**WELWYN HATFIELD BOROUGH COUNCIL
ASSISTANT DIRECTOR (PLANNING)**

DELEGATED APPLICATION

Application No: 6/2024/0616/HOUSE
Location: 41 Northaw Road East Potters Bar Hertfordshire EN6 4LU
Proposal: Erection of a single storey rear extension, a single storey side extension and front porch, following the demolition of the existing side addition, increase in ridge height to facilitate an enlarged loft conversion with the addition of four side dormers, erection of a raised patio to the rear and fenestration alterations
Officer: Ms Elizabeth Mugova

6/2024/0616/HOUSE

Proposal proposed layouts and elevations

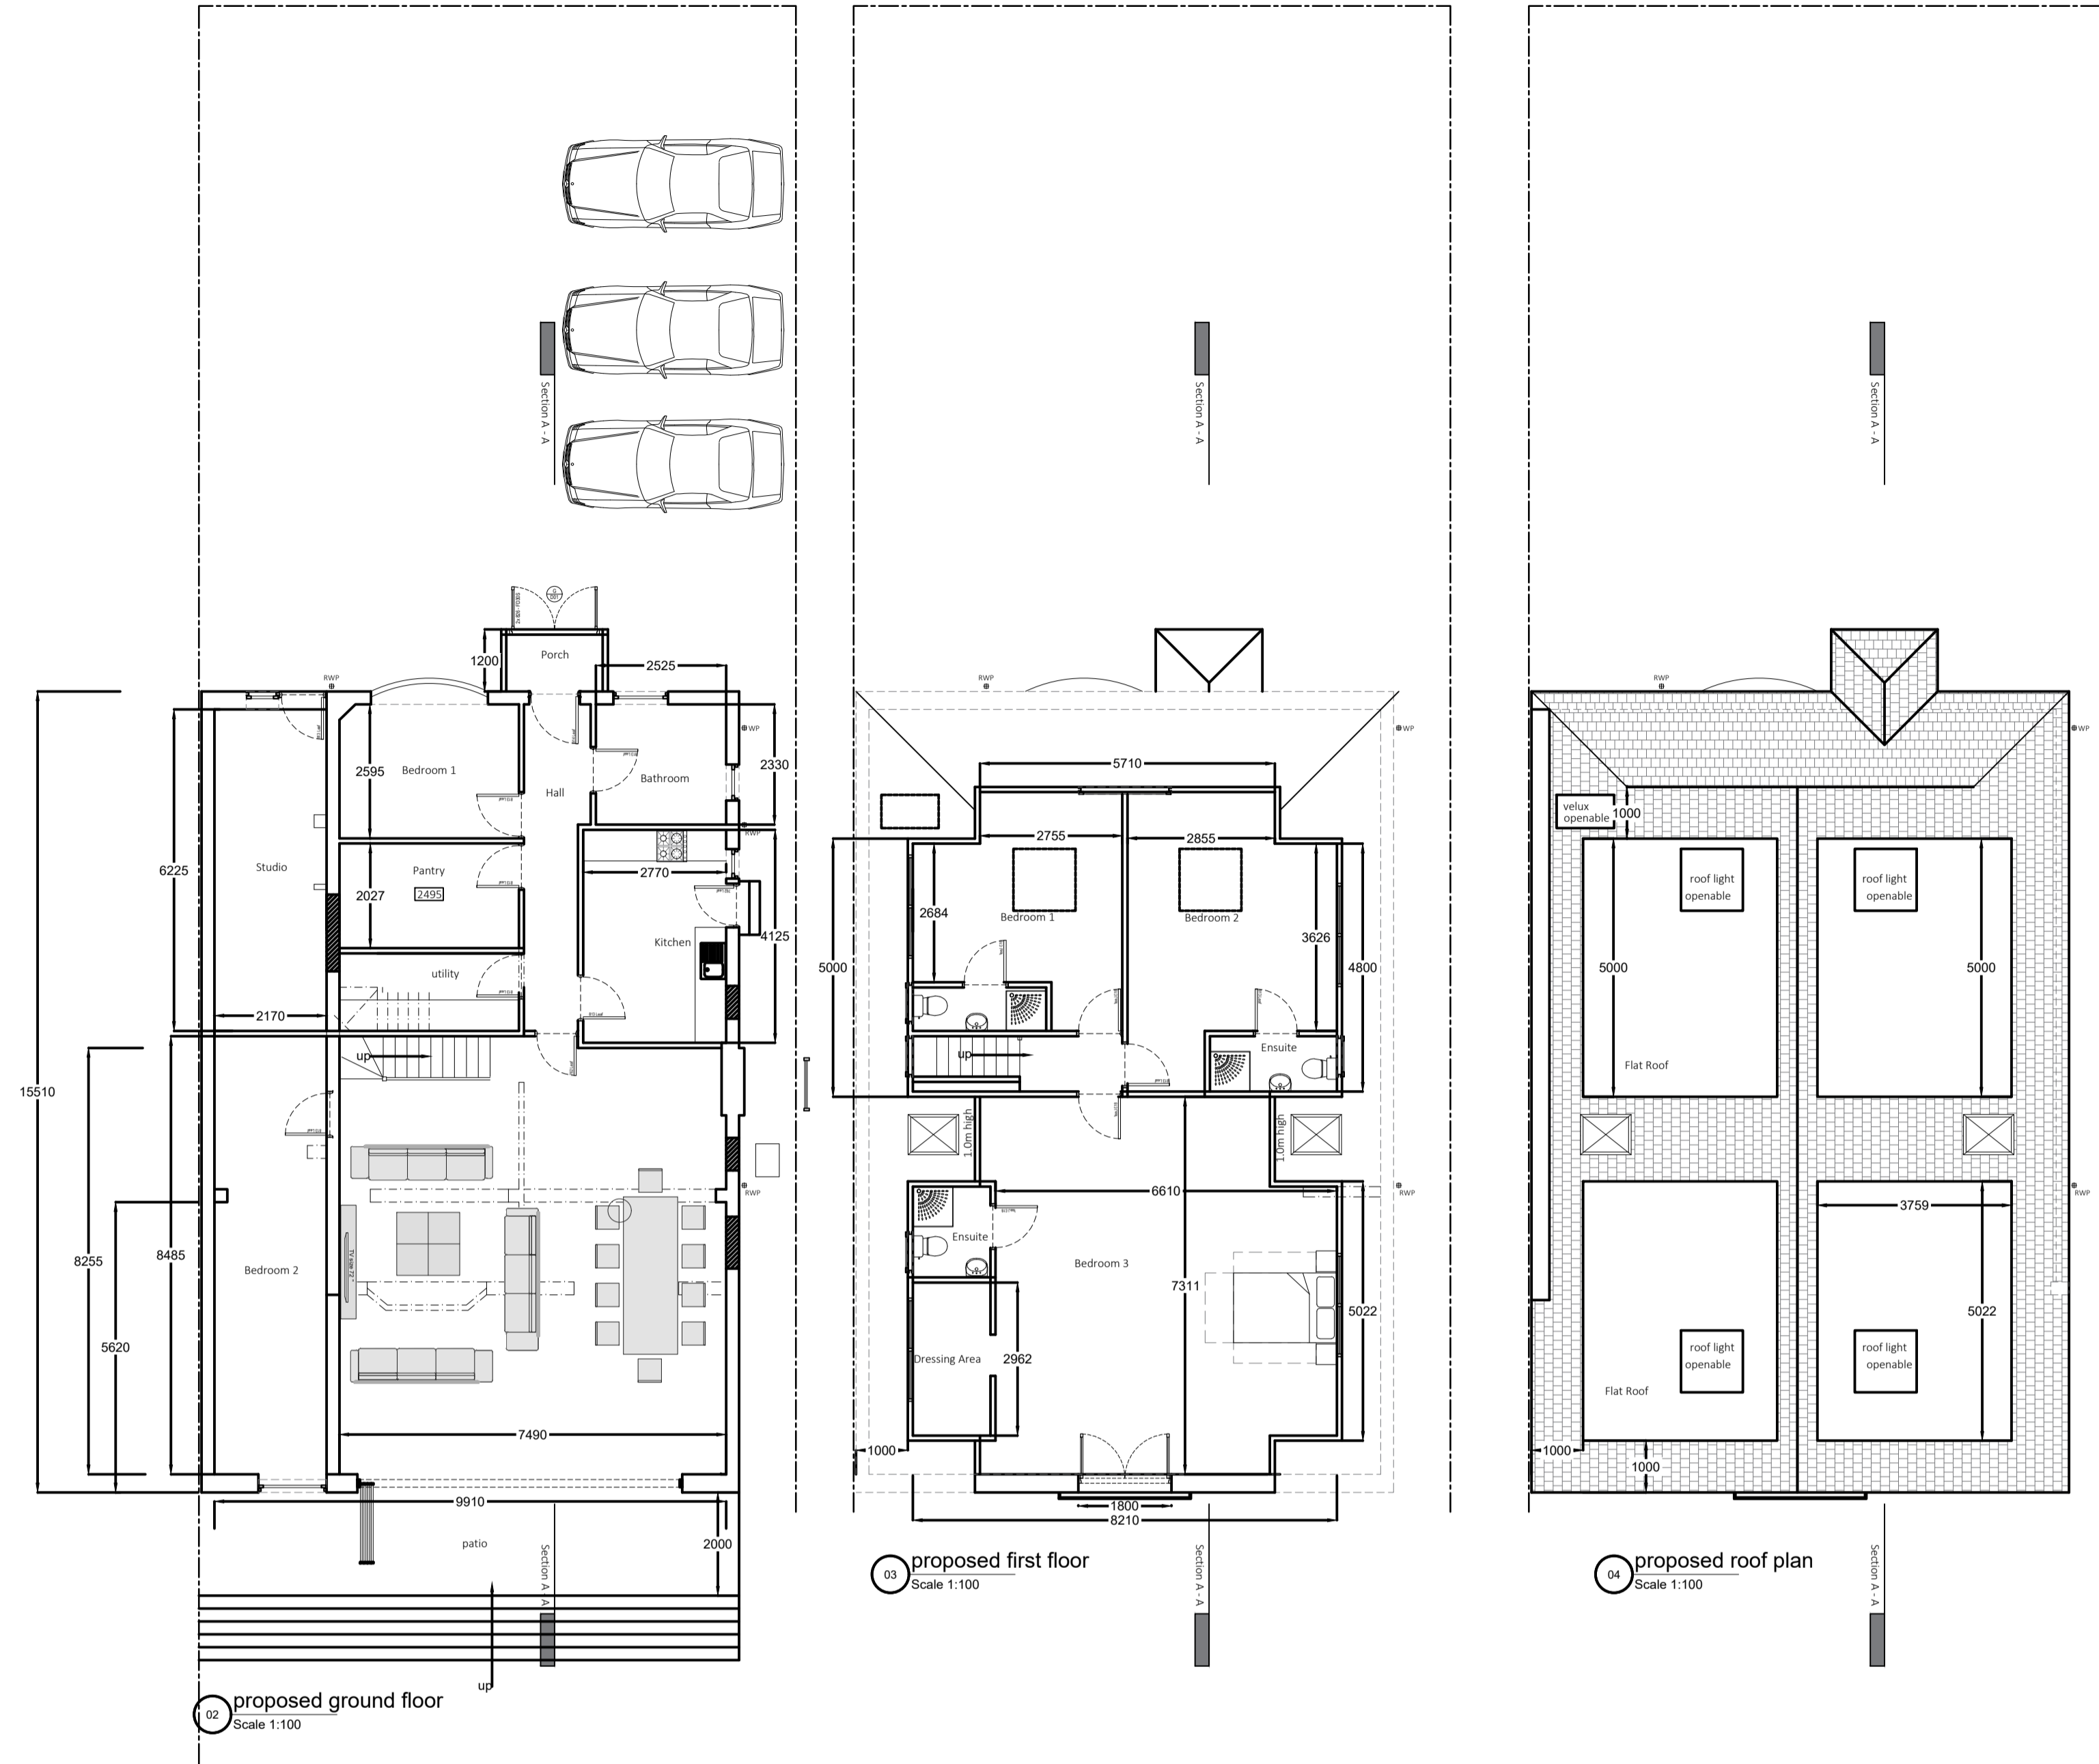
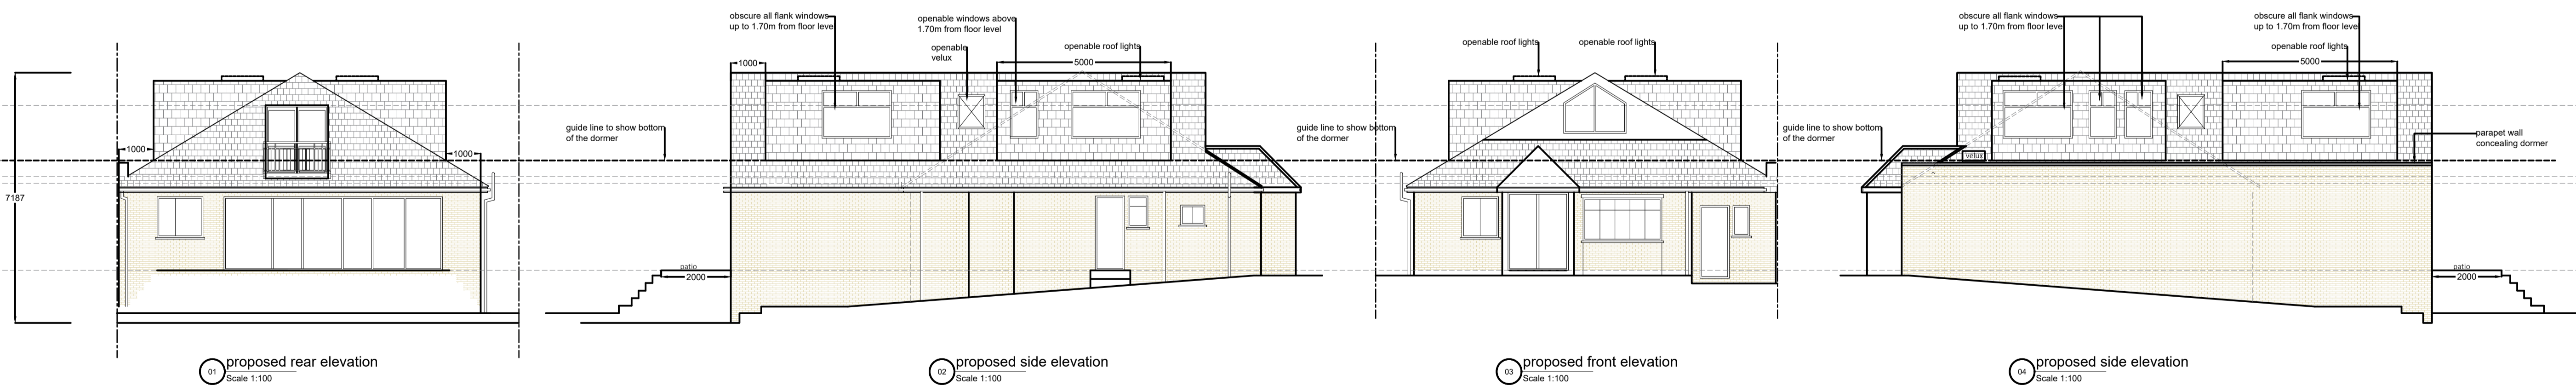
The proposal includes an increase in ridge height to facilitate an enlarged loft conversion with the addition of four side dormers. Land levels at the application site fall in a downward slope from the front towards the rear. There would be a marginal increase in the overall height of the resultant dwelling of approximately 0.5m. It is therefore considered that the increase in ridge height would not disrupt the rhythm of the streetscene.

The proposal includes four long shed dormers which the NCNP consider unacceptable alterations to a roof. While the dormers do not exceed the ridge of the dwelling, they are set very minimally below the ridge, as well as only being minimally set up from the eaves. The dormers therefore occupy the majority of their respective roofslope and would be substantial in comparison to the host dwelling. The dormers are not reflective of the character of the original dwelling and are not considered to represent high quality architectural design. Consequently, the dormers would not fully accord with the NCNP. Additionally, there would be a degree of conflict with Policy SP9 and the SDG. However, the appearance of the resultant dwelling is not considered in isolation; Policy SP9 requires proposals to be respond to the site’s character and surrounding context, including the street scene, having regard to neighbouring buildings in terms of height, mass and scale. There are examples of similar large, long shed dormers within the immediate vicinity of the application site (Nos. 33, 35, 40, 44, 45, 46 and 47). As such, it is considered that these examples inform the character of the area, and this is a material consideration in assessing this application. On balance, it is considered that the proposed dormers would not appear discordant with the character of the area and are therefore considered acceptable in this instance.

The proposed front porch would be limited in depth (approx. 1.2m) with a pitched roof that complements the host dwelling, it would be in keeping with the host dwelling and surrounding area. As such, there is no objection raised regarding this element of the proposal.

The proposed rear extension would be approximately 4m deep and would cover the full width of the rear of the host dwelling and would feature a pitched roof and facilitate loft conversion. The adjoining properties at No 39 and 41 Northaw Road East have had rear extensions and therefore, the impact of the proposal in terms of scale and appearance, would be acceptable. Furthermore, the application site benefits from a large rear garden, therefore, the resultant dwelling would not appear to be cramped when viewed from the rear gardens of adjoining properties.

The application site benefits from a single storey side extension which is set back from the front elevation. The proposal would infill the gap in front of the side extension and would be in line with the

front building line. Additionally, the side extension would feature a parapet wall which would conceal the edge of the dormers facing No. 43 Northaw Road East. In this instance, it is considered that this element of the proposal would not detract from the character and appearance of the host dwelling and the surrounding area.

The proposed raised patio would extend across the width of the rear of the host dwelling and would have a depth of approx. 2m and would be raised by between 1.2m and 1.5m. The patio would be largely screened from neighbours' view by the existing fence and hedge and for this reason would not have a harmful impact on the character and appearance of the host dwelling and surrounding area.

The proposed side dormer windows would have potential overlooking and privacy impacts on the neighbouring occupiers at No. 39 and 43 Northaw Road East. The plans state that dormer windows would be obscure glazed below a height of 1.7 metres. In order to maintain privacy of this neighbouring property, a condition is attached to ensure that these flank windows would be obscure glazed and fixed shut below 1.7 metres.

The rear juliet balcony has the potential for overlooking to parts of the front and rear gardens of adjoining properties at No. 39, 43 Northaw Road East, 46 and 48 Theobald's Road. However, the degree of overlooking would be consistent with a neighbouring relationship generally expected between residential properties and would not result in undue harm to the amenity of neighbours.

Turning to the proposed raised patio, due to the land levels which slope towards the rear, limited depth and height and screening by the fence and hedge, it is considered that the patio would not

unduly impact on the living conditions of neighbouring occupiers in terms of overlooking or loss of privacy. Therefore, an obscure screen would not be required on the side elevations to protect the amenity of neighbouring occupiers at No 39 and 43 Northaw East.

2. The side dormer windows [facing No 39 and 41 Northaw Road East] of the building hereby approved must be obscure-glazed to a level equivalent to Pilkington Level 3 or above and non-opening unless the parts of the window which can be opened are more than 1.7 metres above the floor of the room in which the window is installed, and shall be retained in that form thereafter. Obscure glazing does not include applied film or one-way glass.
